**Our ref:** WA/2015/120640/07-L01

**Deadline 4 (26 November 2015) – Written summaries of oral submissions presented at issue specific hearings on 17, 18 and 19 November 2015.**

### **Development Consent Order Application M4 - Junctions 3-12 (Smart Motorway)**

| 514451-MUH-00-ZZ-DR-DR-400156 | 11 |

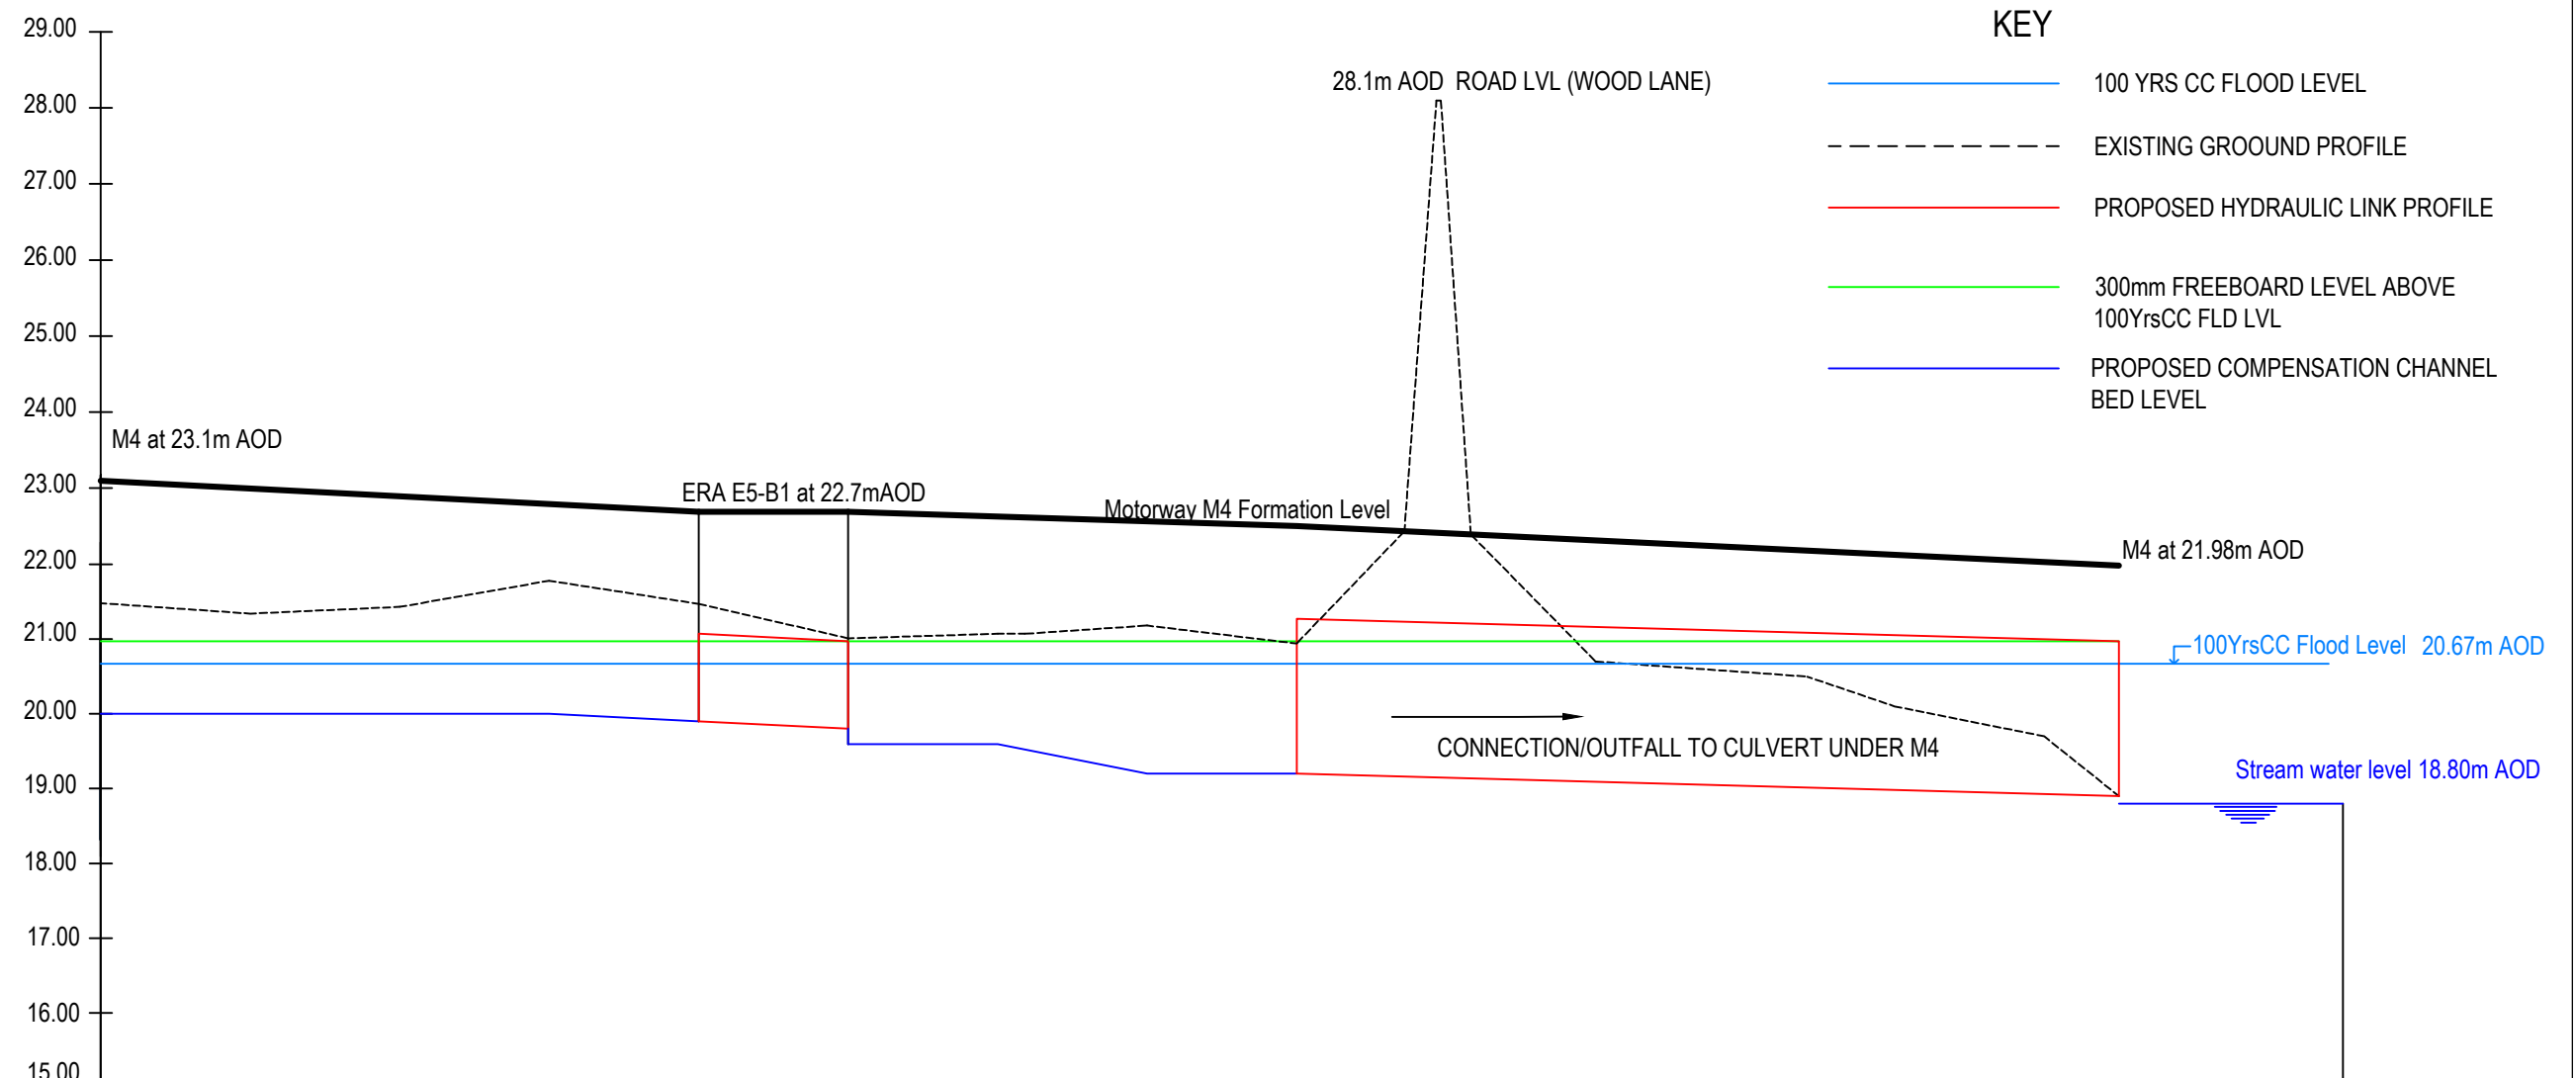
- 3.12 The following comments relate to particular sites/areas where floodplain compensation is proposed.
- 3.13 **Area R18** (WB), Junction 7-6 (CH 26500-27100) and **Area R19** (EB), Junction 7-6 (CH 26550-27070), drawing 514451-MUH-00-ZZ-DR-DR-400157.

A cross section for this area has been submitted, which supports the written summary of compensation calculations as shown in Table 1. The invert level of the culvert is shown to be flat. Due to the length of the connectivity, we have concern about whether flood water would be able to recede back to the flood plain. There is limited information about the culvert link across the motorway is shown on the plan and how this will be used.
